DEVELOPMENT REVIEW BOARD
SUPPLEMENTAL SUBMITTAL

PROJECT NO. PR-2021-006070

Application No. SI-2021-01889

Re: Westpointe40 North Site Plan DRB Comment Responses (PR-2021-006070)

DRAWING SHEET  
L101

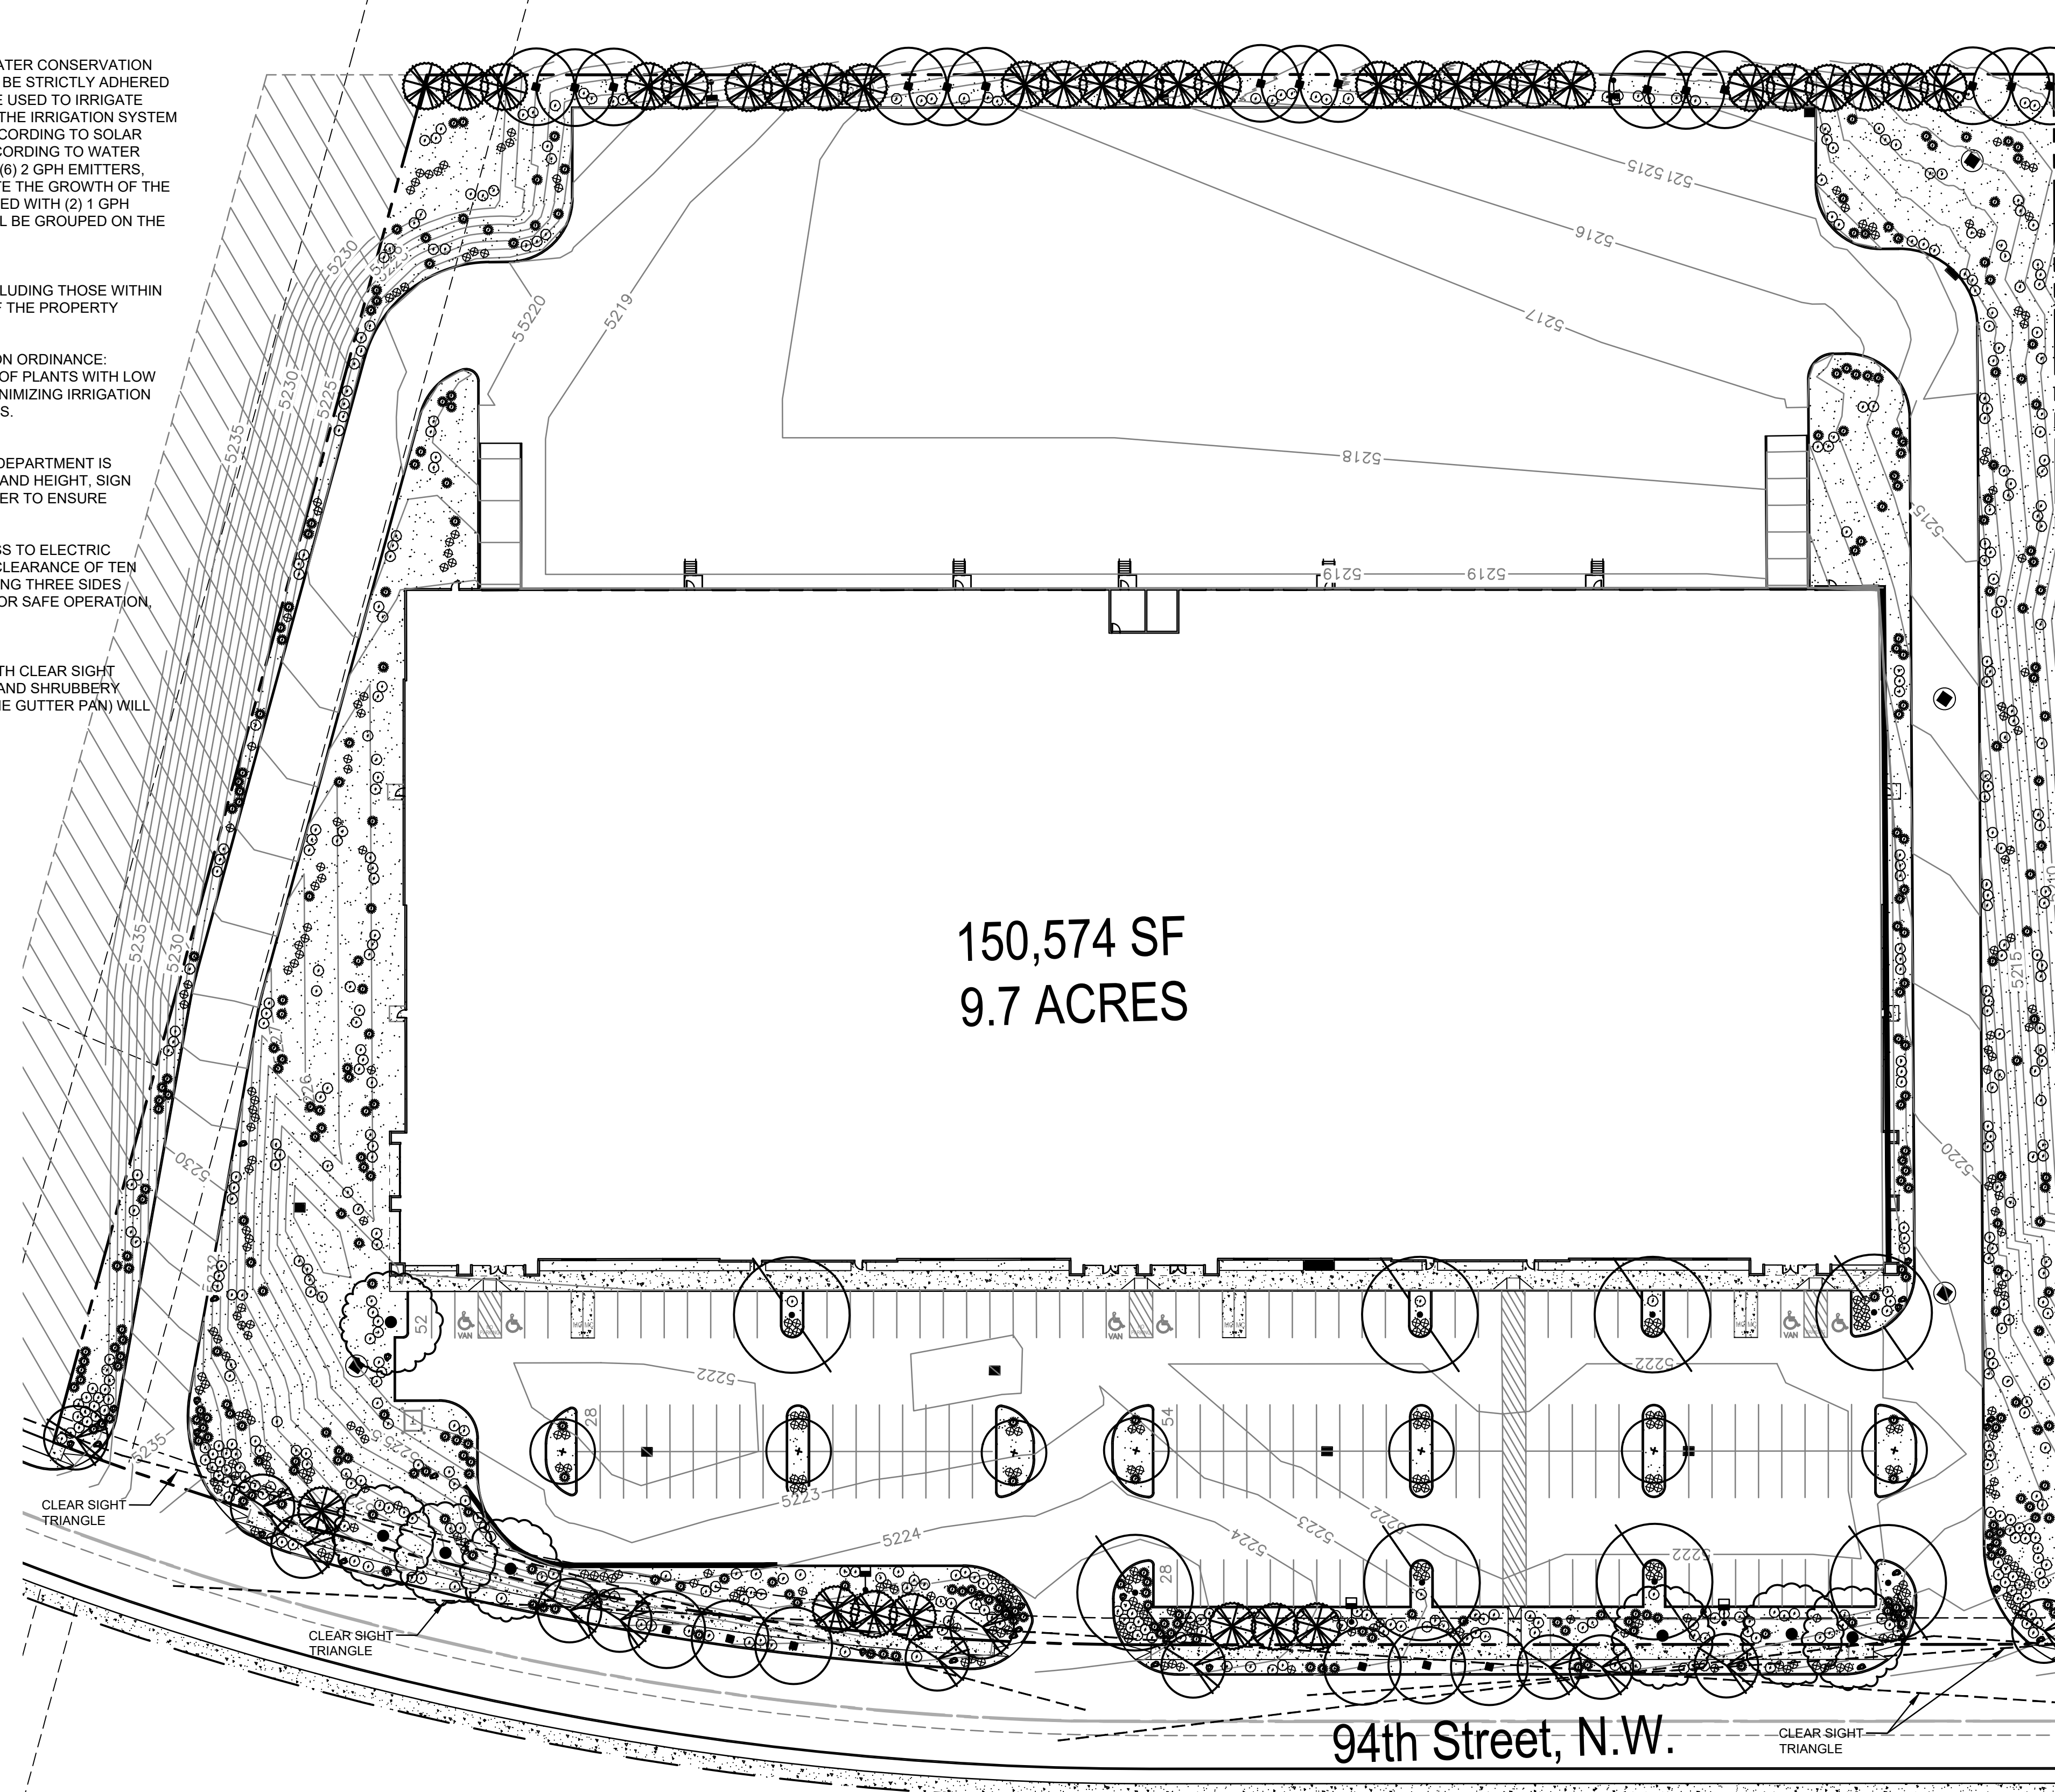
4. With the clear sight triangles shown on the landscape plan, will height restrictions be met? It is not clear.
 - *The landscape plan is showing street trees that are required along Daytona Road to comply with the IDO and Street Tree Ordinance. Within the clear sight triangle, these trees will need to be maintained and will be pruned to meet the minimum clearances.*
